From: Adam Smith
Sent: Wednesday, 17 December 2014 10:44 AM
To: Lance Newley
Subject: FW: service station concept

From: melissa.kahler@dpi.nsw.gov.au [mailto:melissa.kahler@dpi.nsw.gov.au]
Sent: Wednesday, 26 March 2014 3:21 PM
To: Adam Smith
Subject: RE: service station concept

From: Adam Smith
Sent: Friday, 21 March 2014 1:41 PM
To: 'andrew.scott@dpi.nsw.gov.au'
Cc: melissa.kahler@dpi.nsw.gov.au
Subject: RE: service station concept

The landowner has proceeded along with investigations associated with Precinct 1 (with respect to a proposed future service station). A copy of this plan (conceptually only) is attached. The landowner has also had a detailed LUCRA assessment carried out in respect of the conceptual service station proposal. A copy of this is attached inclusive of recommended buffering. In consultation with the Hazardous Goods expert we have also ensured that the proposal, in conjunction with fencing, suitably protects the adjoining site from unnecessary potential adverse impacts (such as fire and the like).

Appendix 1: Proposed Service Station - site plan

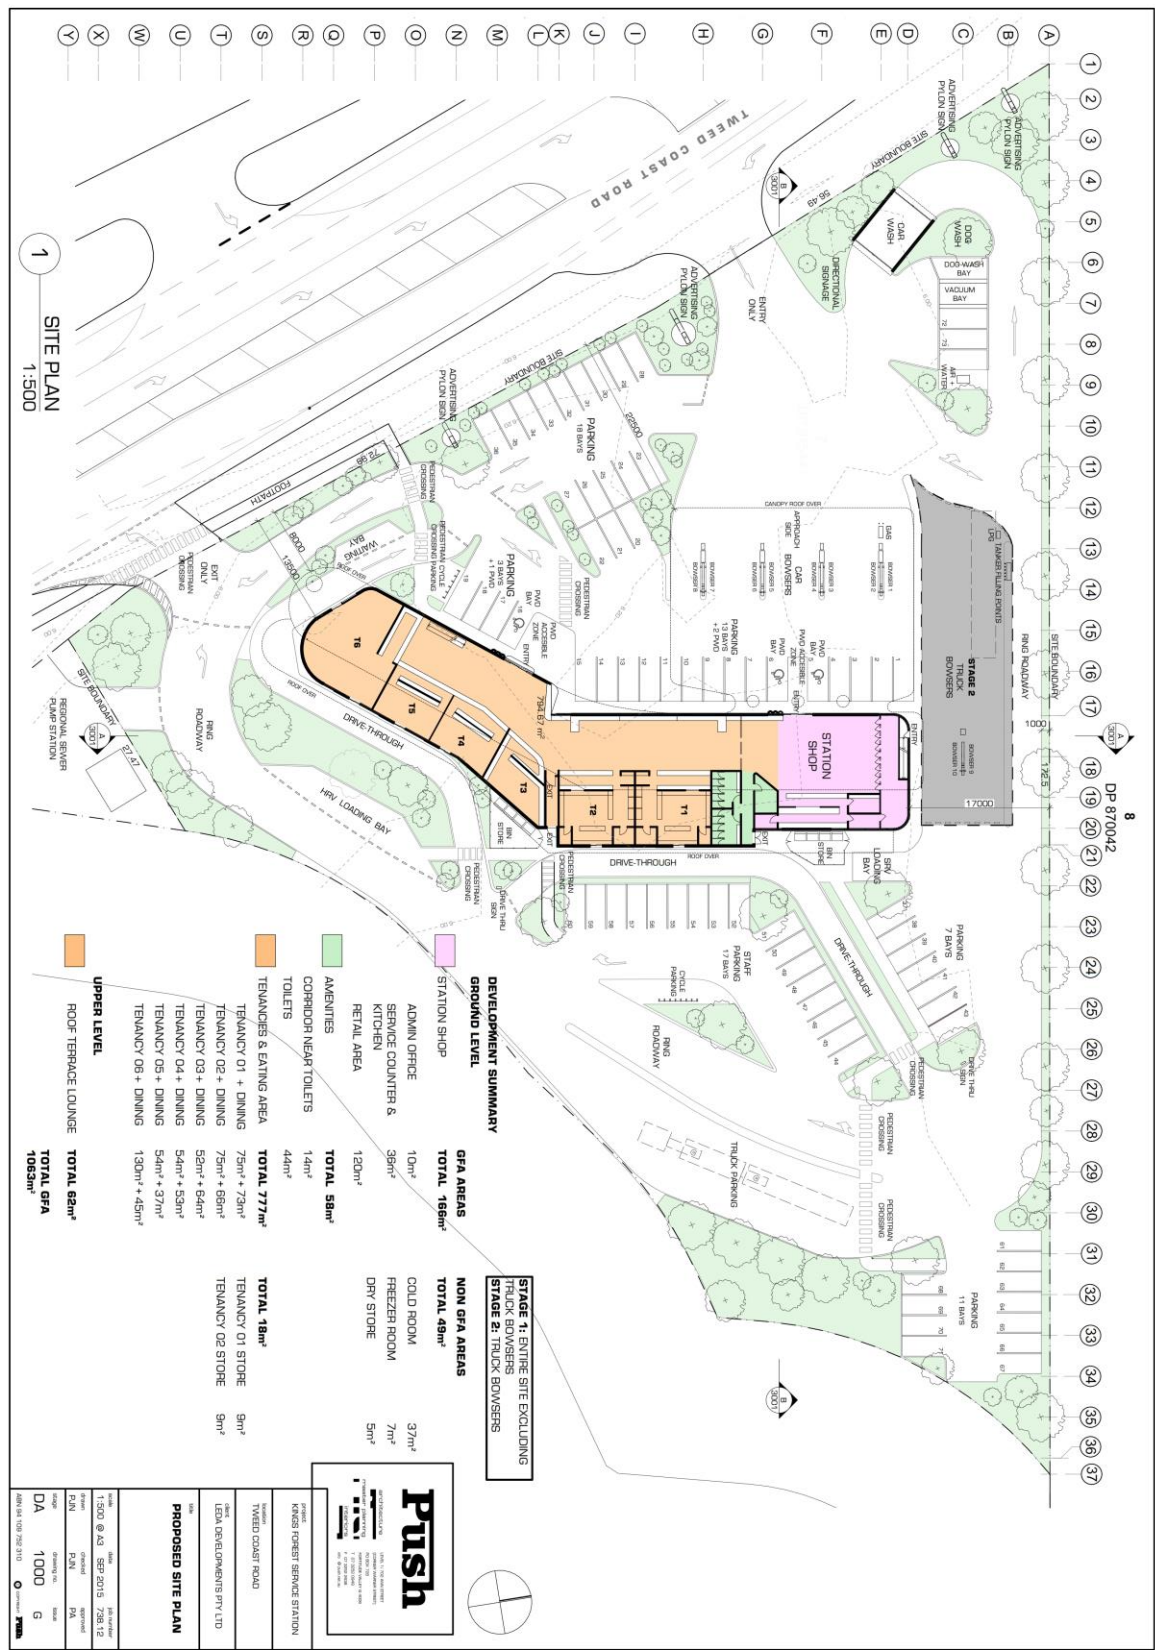
- The use of a wallum scrub (on the neighbouring property) as a vegetative buffer is not preferred, a denser vegetation type would be more effective. Particularly since it is the onus of the developer to mitigate any future impact, additional fencing and/or vegetation buffers on the proponents land could be further considered.

What set backs or mitigation measures do you consider appropriate to avoid the risk of a service station fire on the plantation or a plantation fire on the service station? and what are your references supporting your assumptions?
